From: Martyn White
Sent: 29 August 2019 17:20
To: Amber Willard <Amber.Willard@arun.gov.uk>
Subject: AW/212/19/HH

AW/212/19/HH

The application seeks to make comprehensive alterations to the building, including the replacement of an existing extension and conservatory with a single storey rear extension, balcony area and a loft conversion. It also proposes

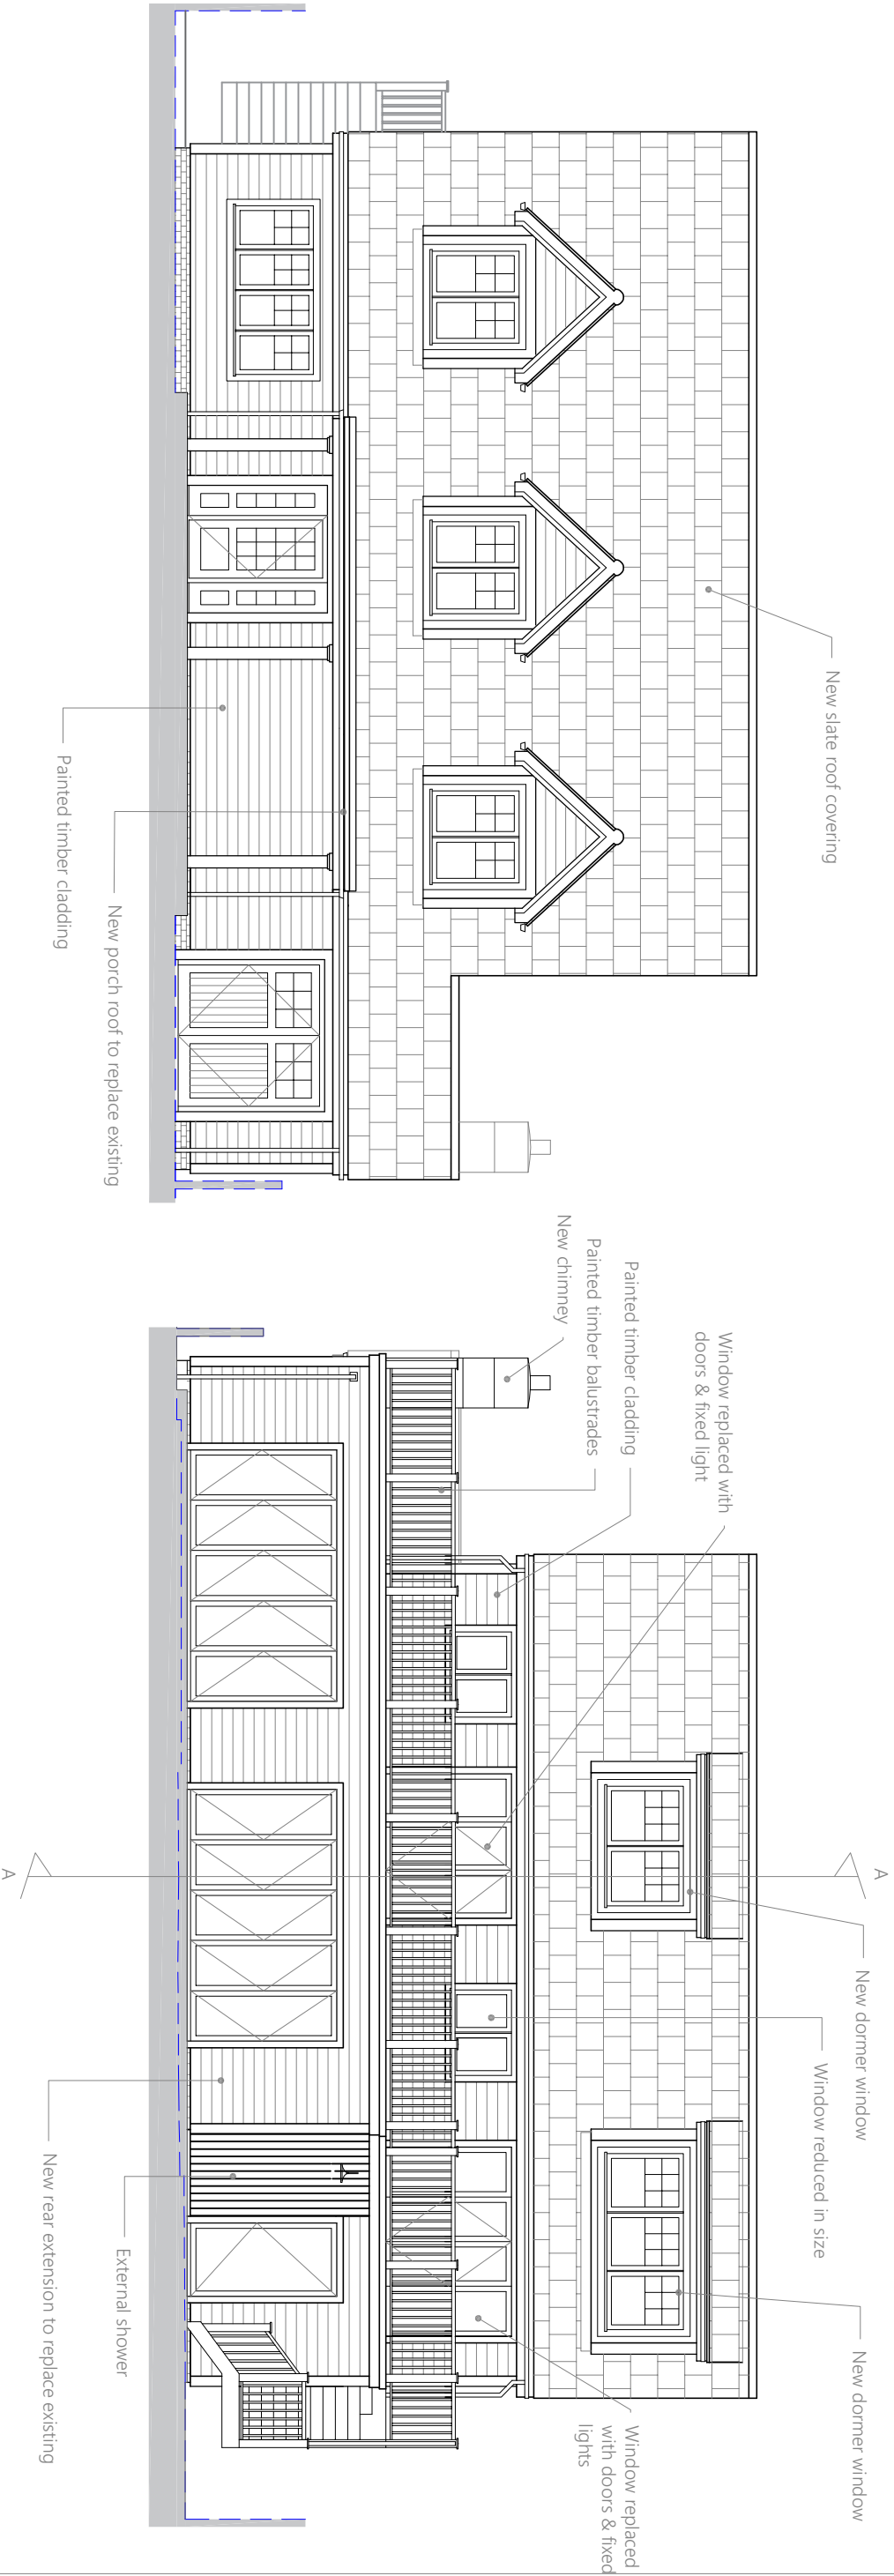
However, the principal concern relates to the alterations to the materials to be used for the external appearance of the building. As previously mentioned, the estate attempts to reflect a more traditional aesthetic where a Tudor appearance was preferred.

The use of painted cladding on all of the elevations and slate on the roof provides the building with a more 'New England' appearance, which is not normally associated with the conservation area. It is therefore considered to conflict with the established character of the estate.
